RMS Reference: SYD16/00625/08

DP&E Reference: SSD7684

AMENDED CONCEPT PROPOSAL SSD7684 - STAGED REDEVELOPMENT OF COCKLE BAY WHARF - 241 – 249 WHEAT ROAD, COCKLE BAY DARLING HARBOUR

Future RMS Projects and Structural Zones

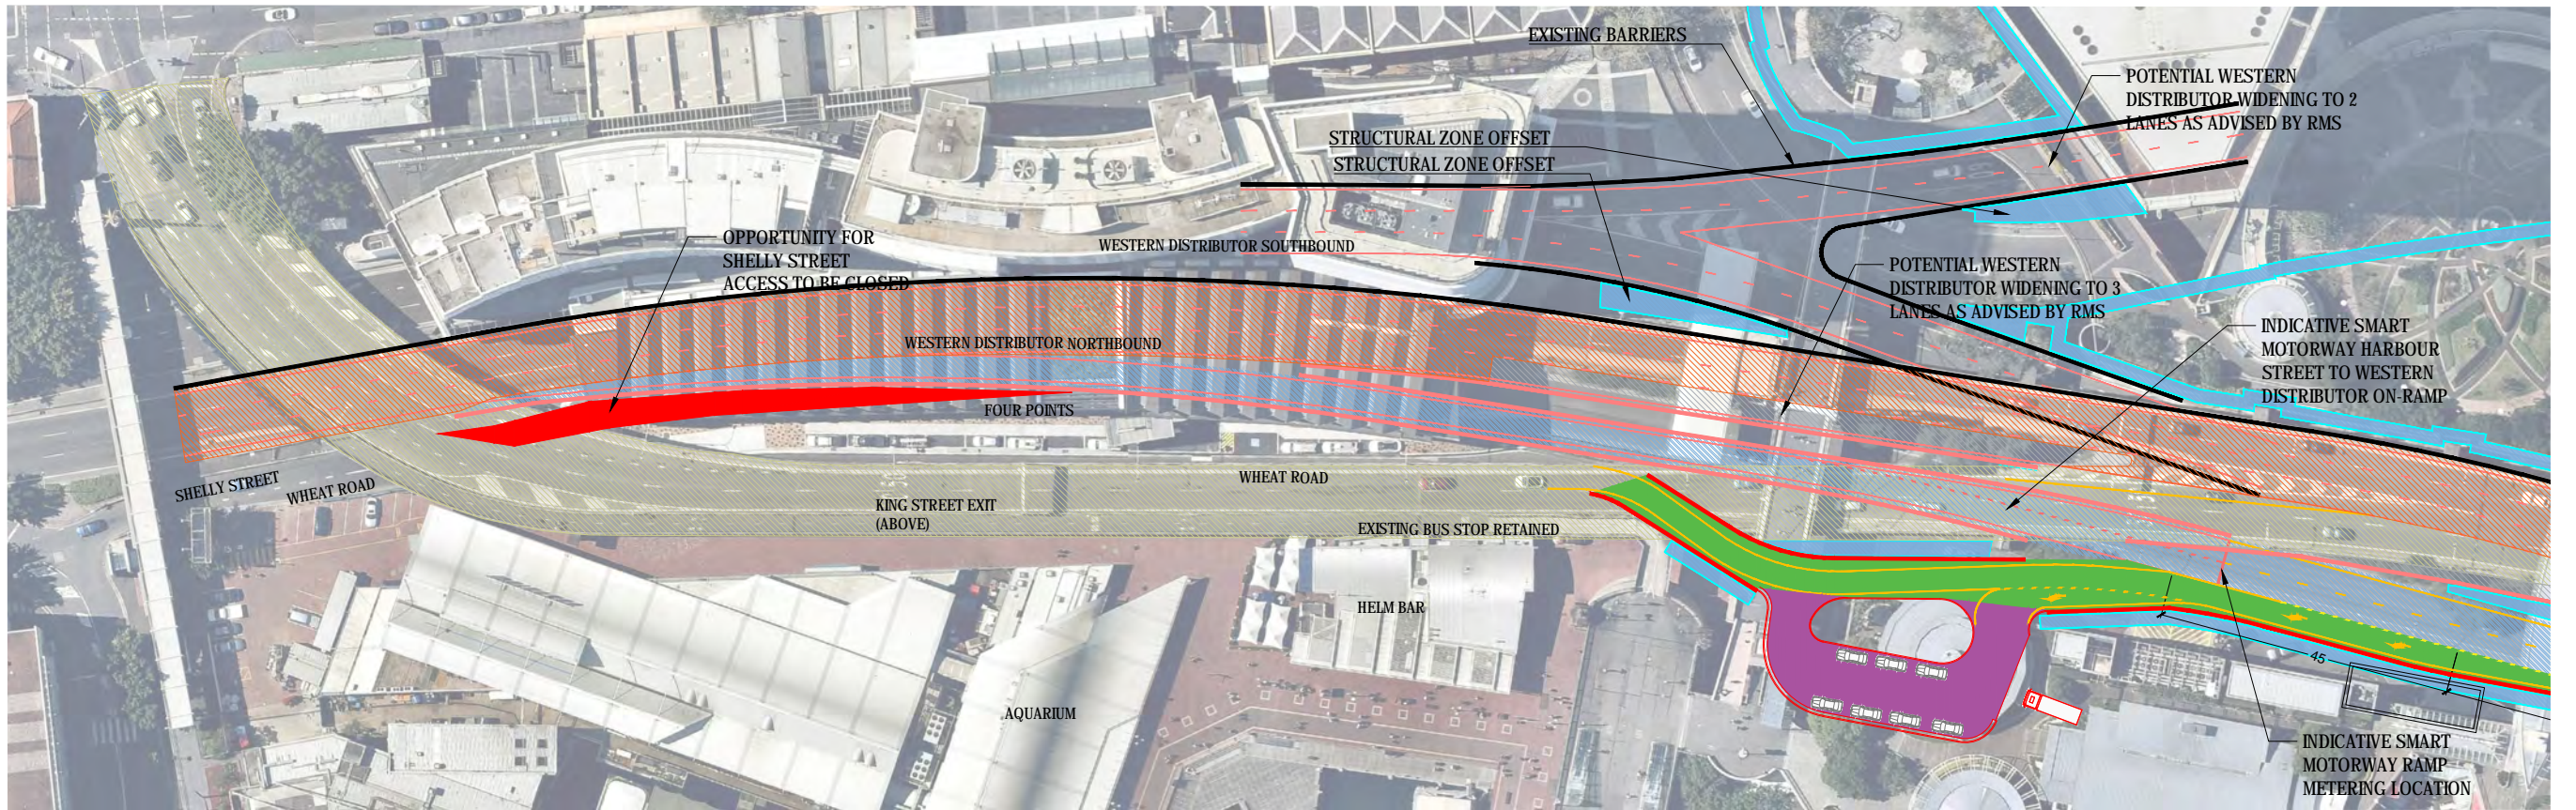
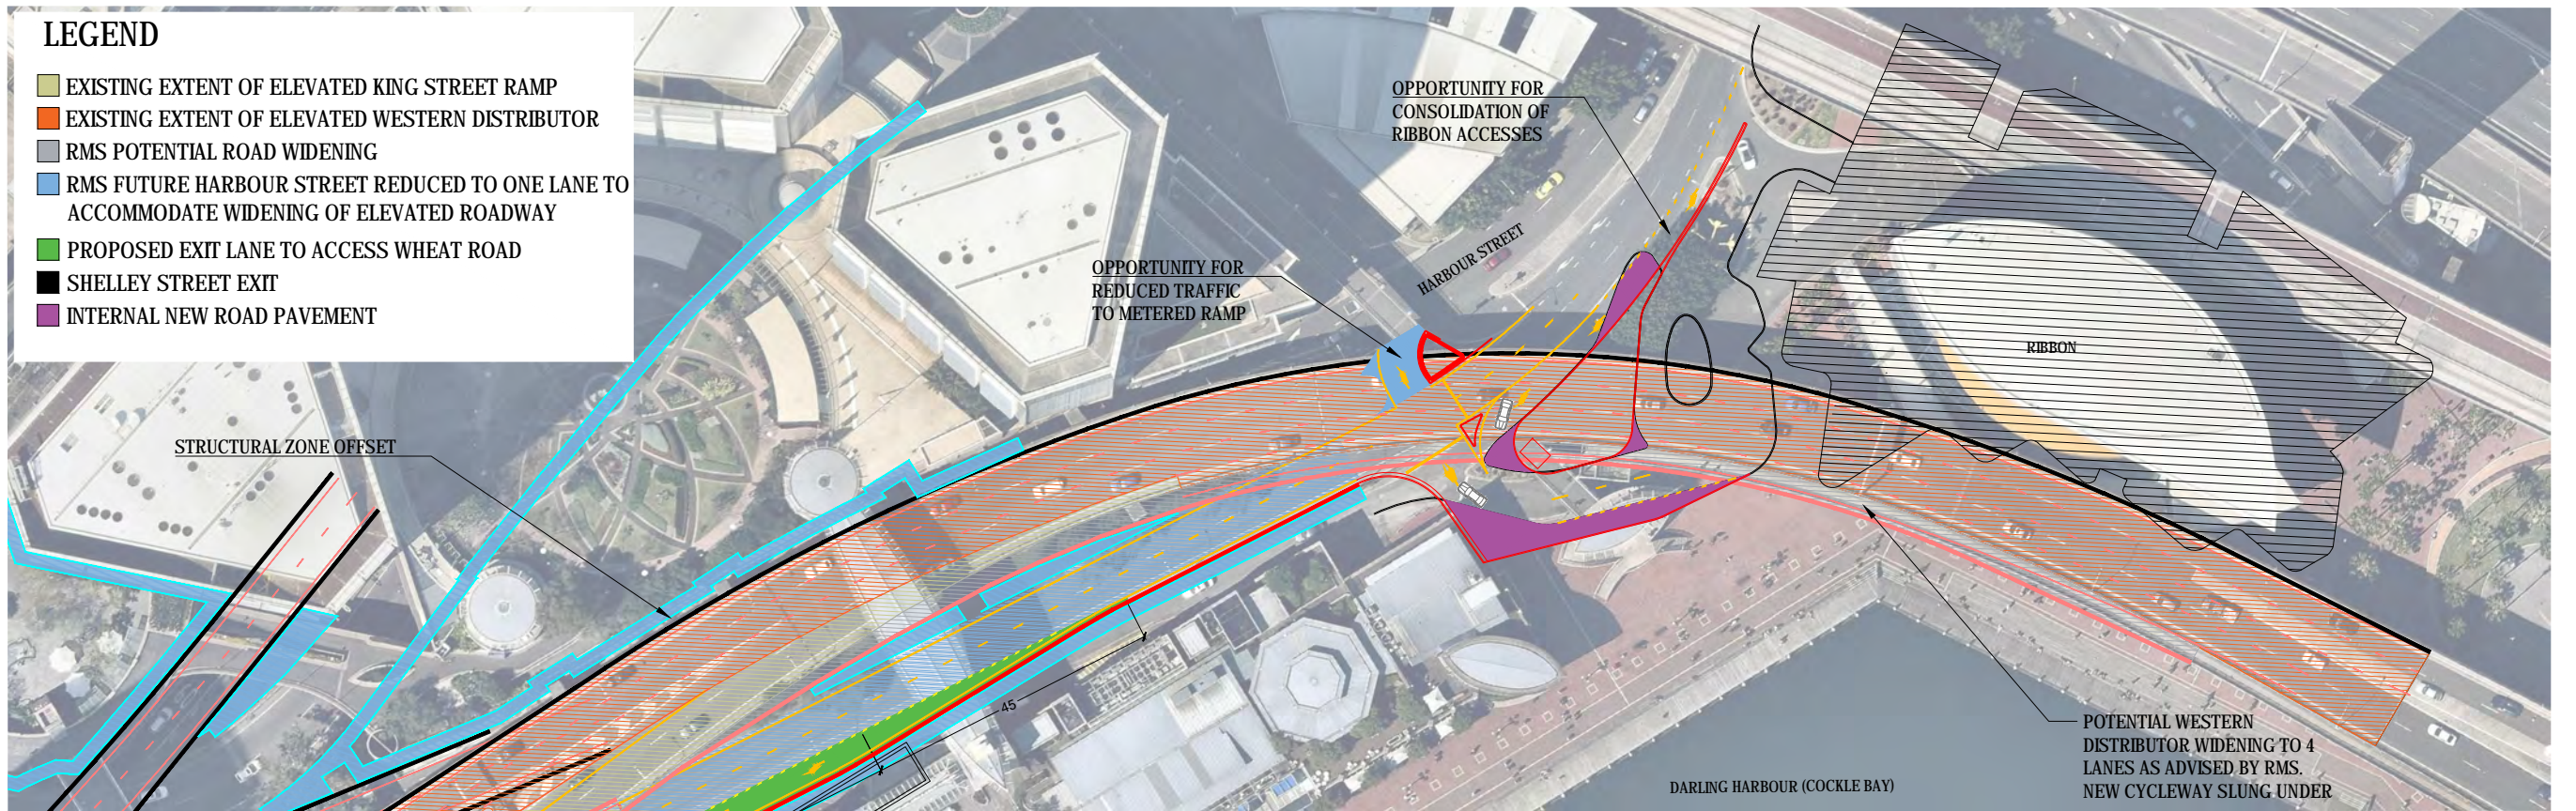
9. **Pier Options** – Roads and Maritime is currently undertaking planning and feasibility assessments for the implementation of smart technologies and associated infrastructure upgrades within this corridor. In order to not limit the development of workable design options, it is imperative that the existing road corridor width (between existing barriers and kerbs) beneath the Project is maintained.

Roads and Maritime previously requested the proponent to identify where the piers for the Podium are proposed to be located in relation to the Western Distributor, including a "no piers" in addition to the proposed "piers" option. To ensure that the Project will not preclude future infrastructure upgrades in the subject corridor, Roads and Maritime requires that the existing road corridor width (between existing barriers and kerbs) beneath the Project is maintained. In this regard:

1. No piers are to be located within the road reserve of the Western Distributor, Wheat Road or Harbour Street.
2. Proposed structures within Zone B, Zone G and Zone H would not be supported.
3. Vehicle roll allowance clearances must be provided when positioning piers.
4. All existing signage impacted by the proposed works would need to be maintained/reinstated.

Note: The abovementioned zones are as defined in 'CBW Land Bridge and Options Strategy – 170619'.

**COCKLE BAY PARK
INTENT OF CLEARANCE TO ELEVATED WESTERN DISTRIBUTOR
STRUCTURE**

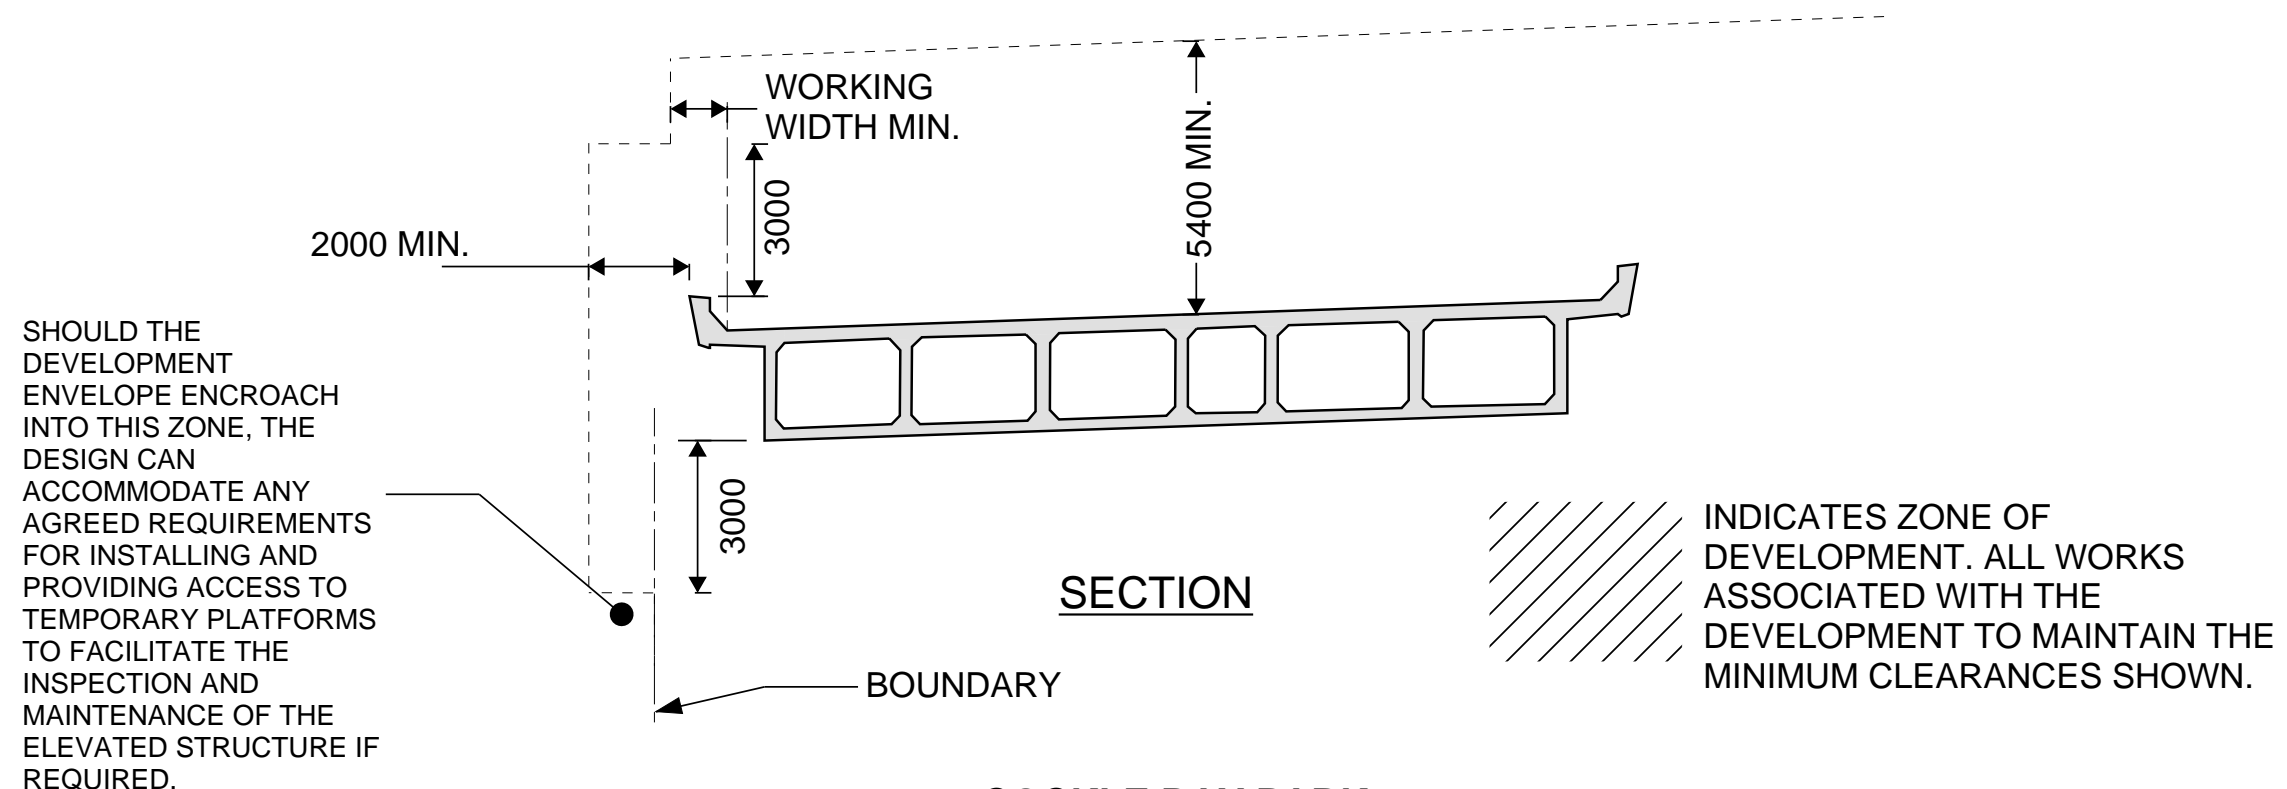
13. **Minimum Clearance** – the proponent will need to demonstrate that the land bridge and other works built over and in the vicinity of the WD maintain clearance as per RMS requirements.

- Proposed clearance from the Podium to each part of the adjacent Roads and Maritime structure and road, including (but limited to) the deck, column, pile cap and other structures.

**COCKLE BAY PARK LANDBRIDGE -
DEMOLITION AND REPLACEMENT OF
THE WESTERN DISTRIBUTOR**

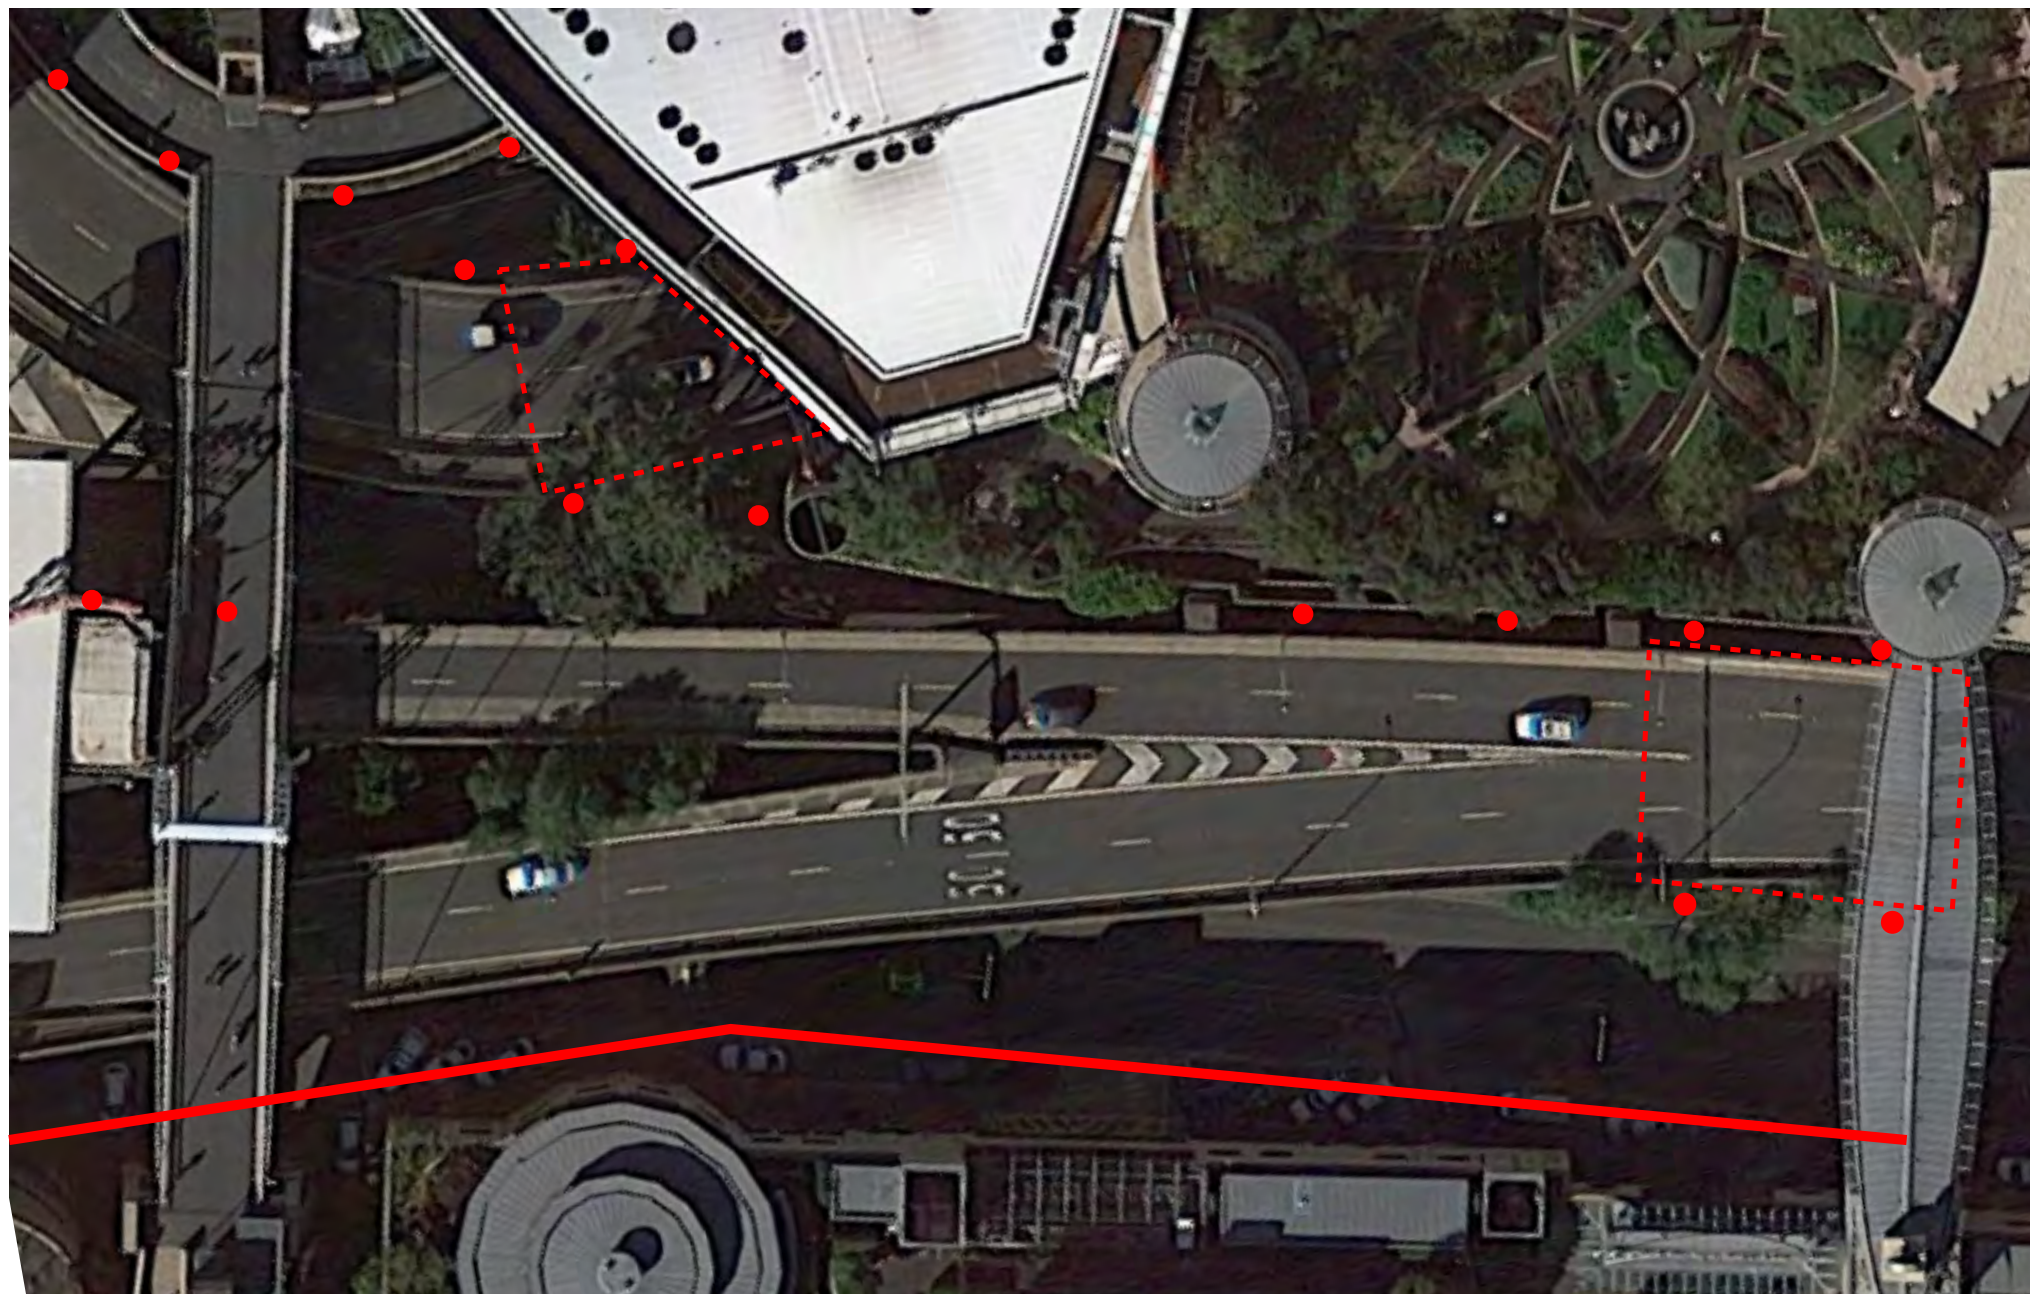
As the proposed development would cover significant areas of the existing bridges, the level of risk to the maintenance of the bridges needs to be assessed. The current proposal is likely to obstruct Roads and Maritime's major maintenance works on Western Distributor bridges B 6794 and B 8565. In this regard, a demolition and reconstruction plan is required.

The demolition and reconstruction plan will need to demonstrate that the demolition and reconstruction of the Roads and Maritime bridges at the end of service life will be possible within the available working envelope following the construction of the Podium. Reducing the size of the Podium land bridge may minimise the risk to Roads and Maritime's assets. This should be investigated in consultation with Roads and Maritime in the preparation of the Stage 2 DA.
